**Amended Proposed Rear Elevation**  
 (Please Compare to Approved Document 19DA-PE-001 / Rev 1)

**DRAWING TITLE**  
 Rear Elevation  
**DRAWING NO.**  
 19DA-PL-03-RE

Project  
**New Build**  
**19 Downs Avenue**

Drawing Title:
Existing / Proposed Street Scenes

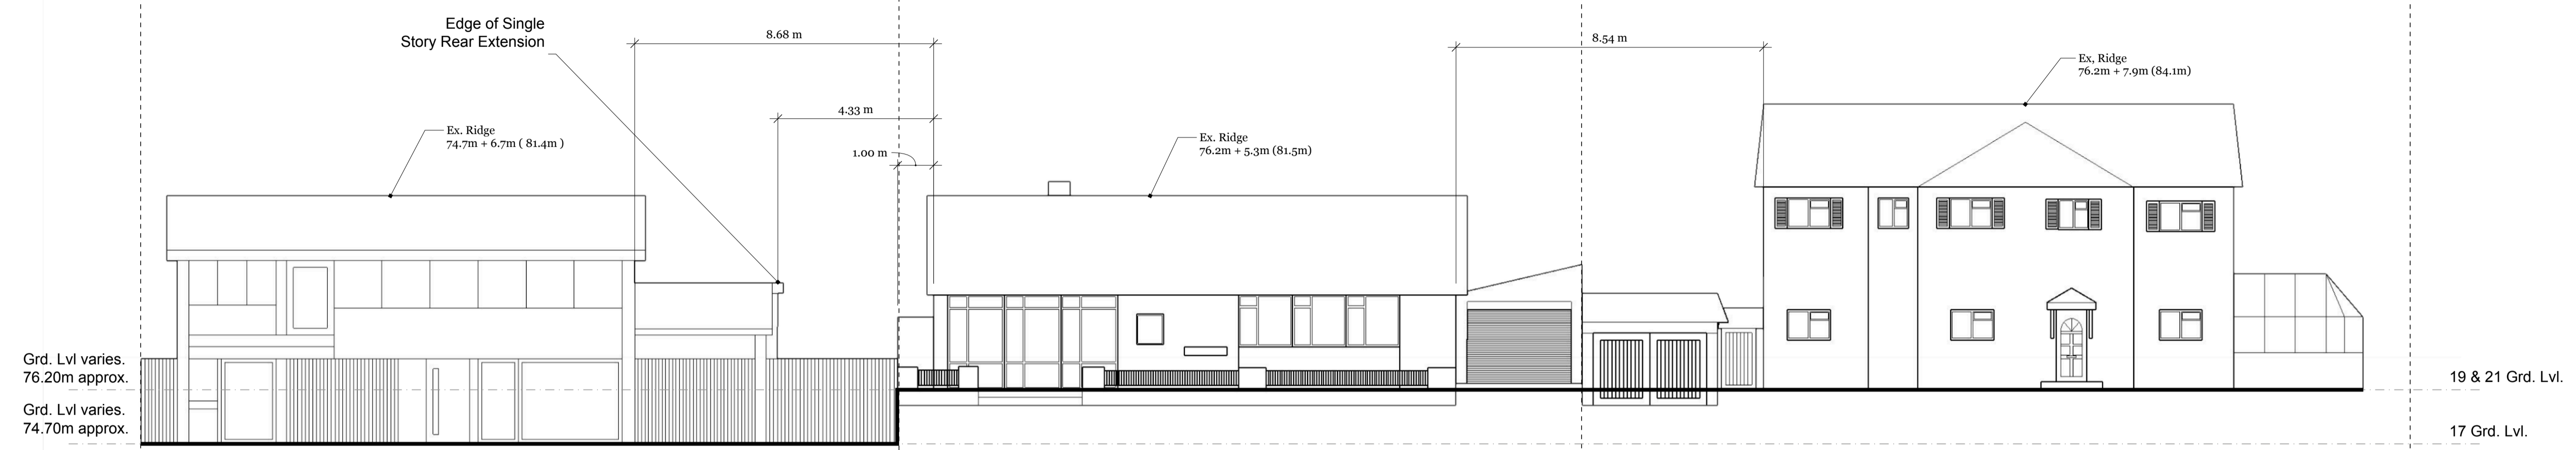
In order to increase the amount of natural light reaching number 17, we are interested in transitioning to a hipped roof design.

To improve the aesthetics of the building we would like to clad the first floor walls: (front, back and both side elevations) with tiles. In the current design only the front gable is clad and the remaining walls are brick.
